”KRISTIN ESTATES” Closure Sheets

BOUNDARY

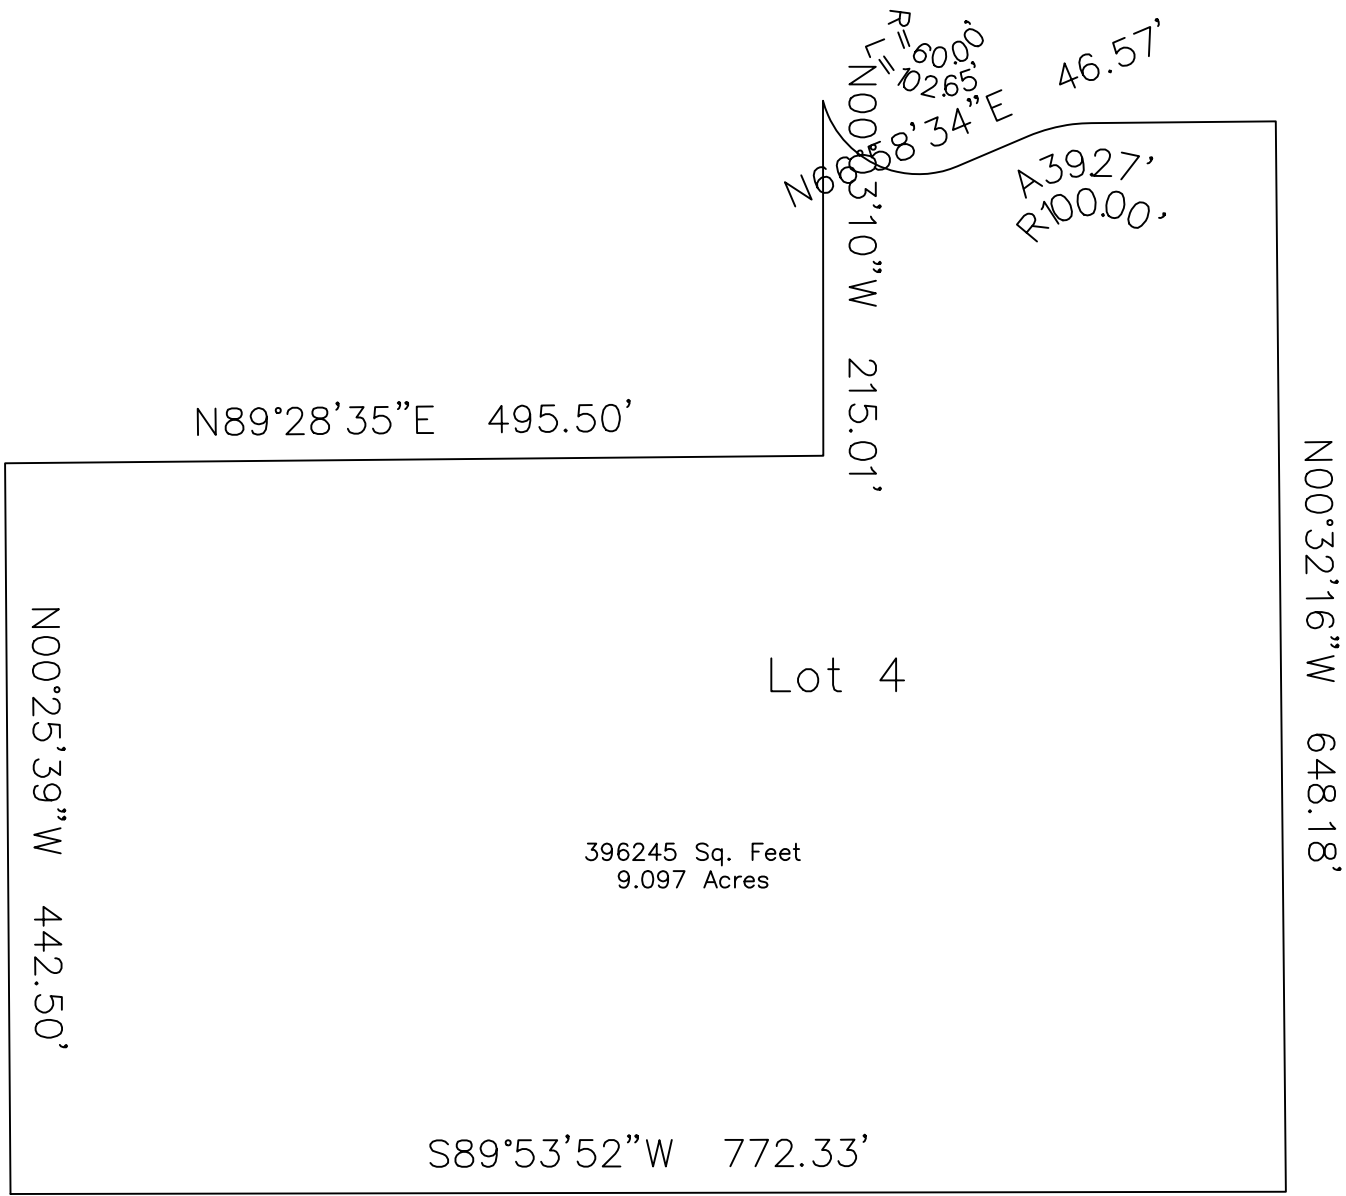
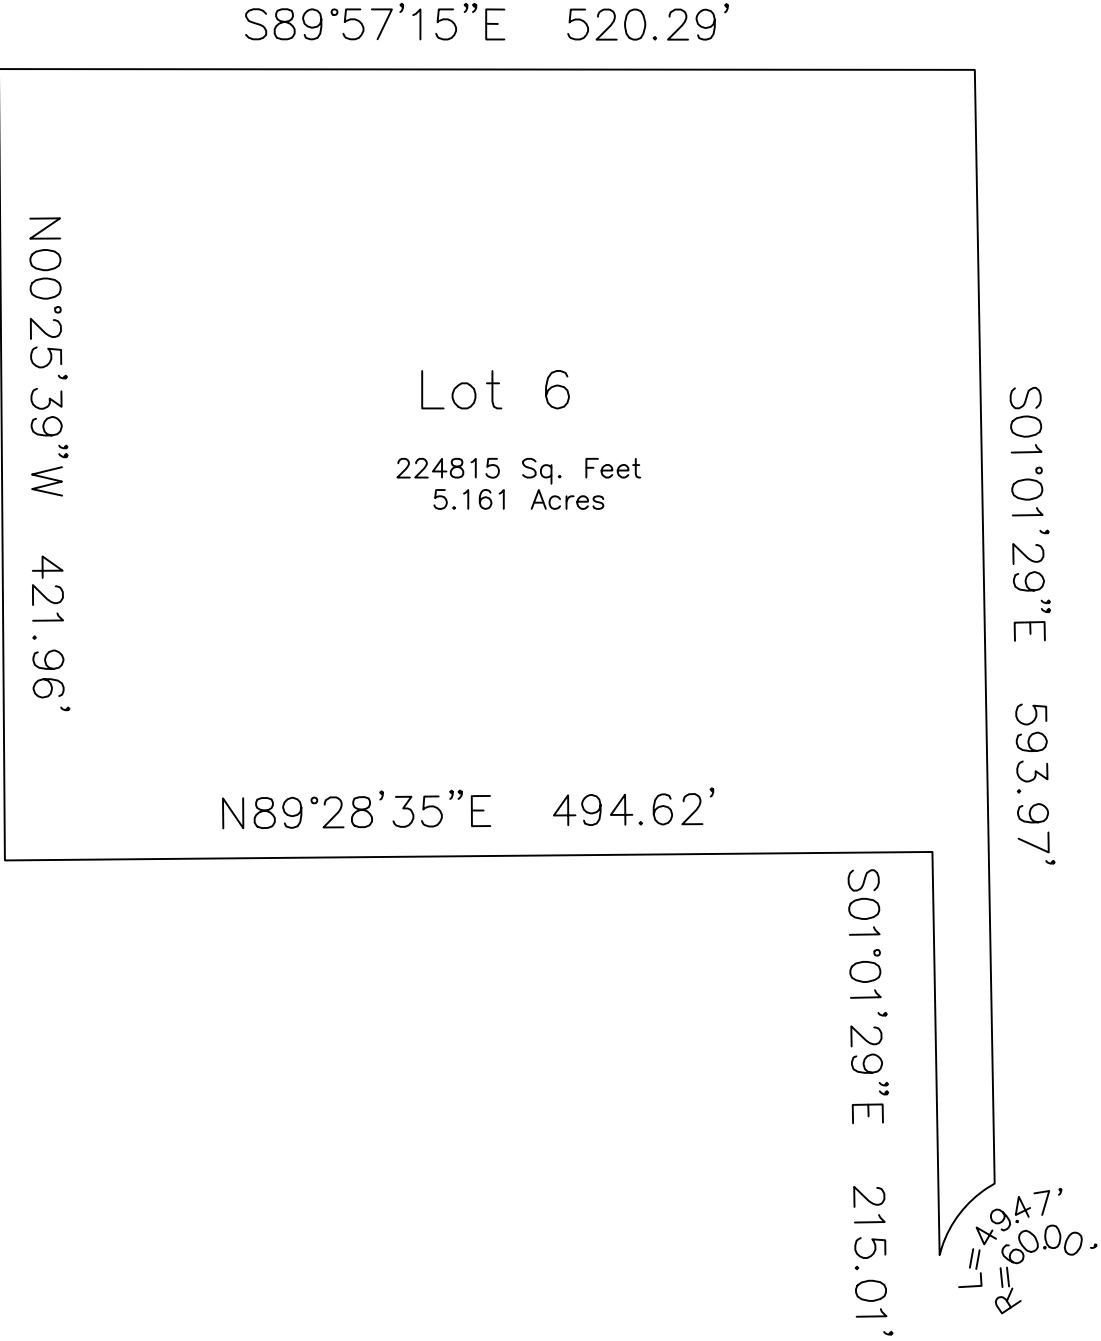
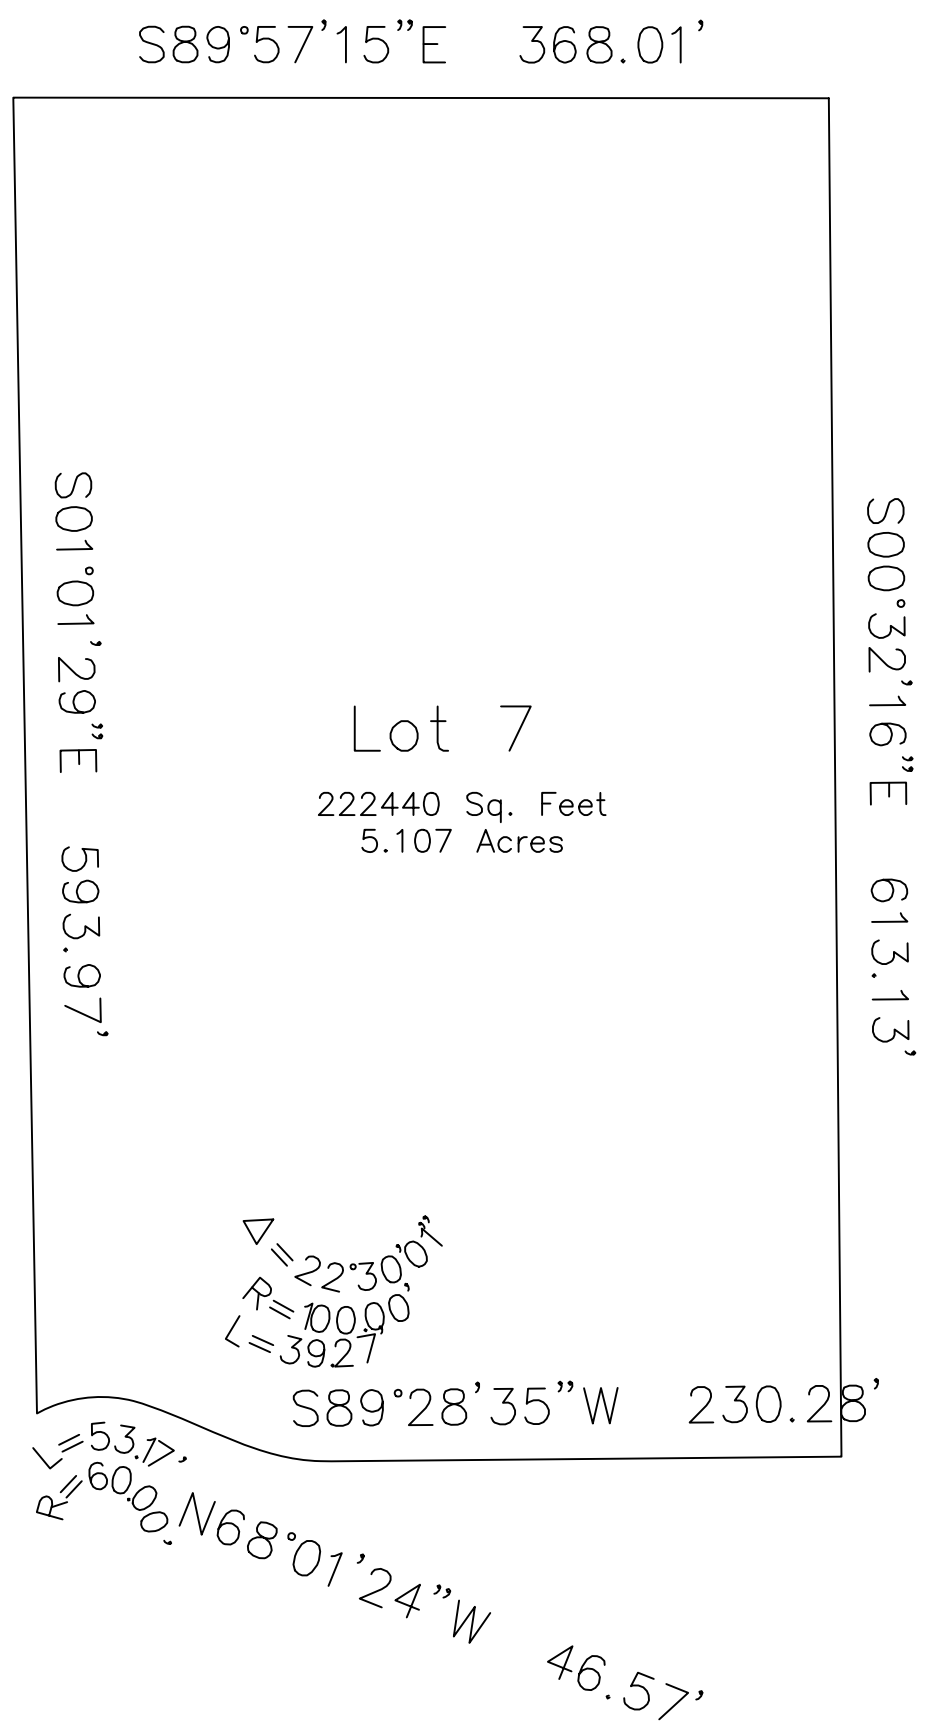
Unresolved Review 1
Comment:
Lot 11 bearing is
inconsistent with
boundary bearing.

Unresolved Review 1
Comment:
Lot 11 bearing is
inconsistent with
boundary bearing.

Tract A removed from closure for this
submittal. Please add it back in and verify
that it matches the final plat drawing.
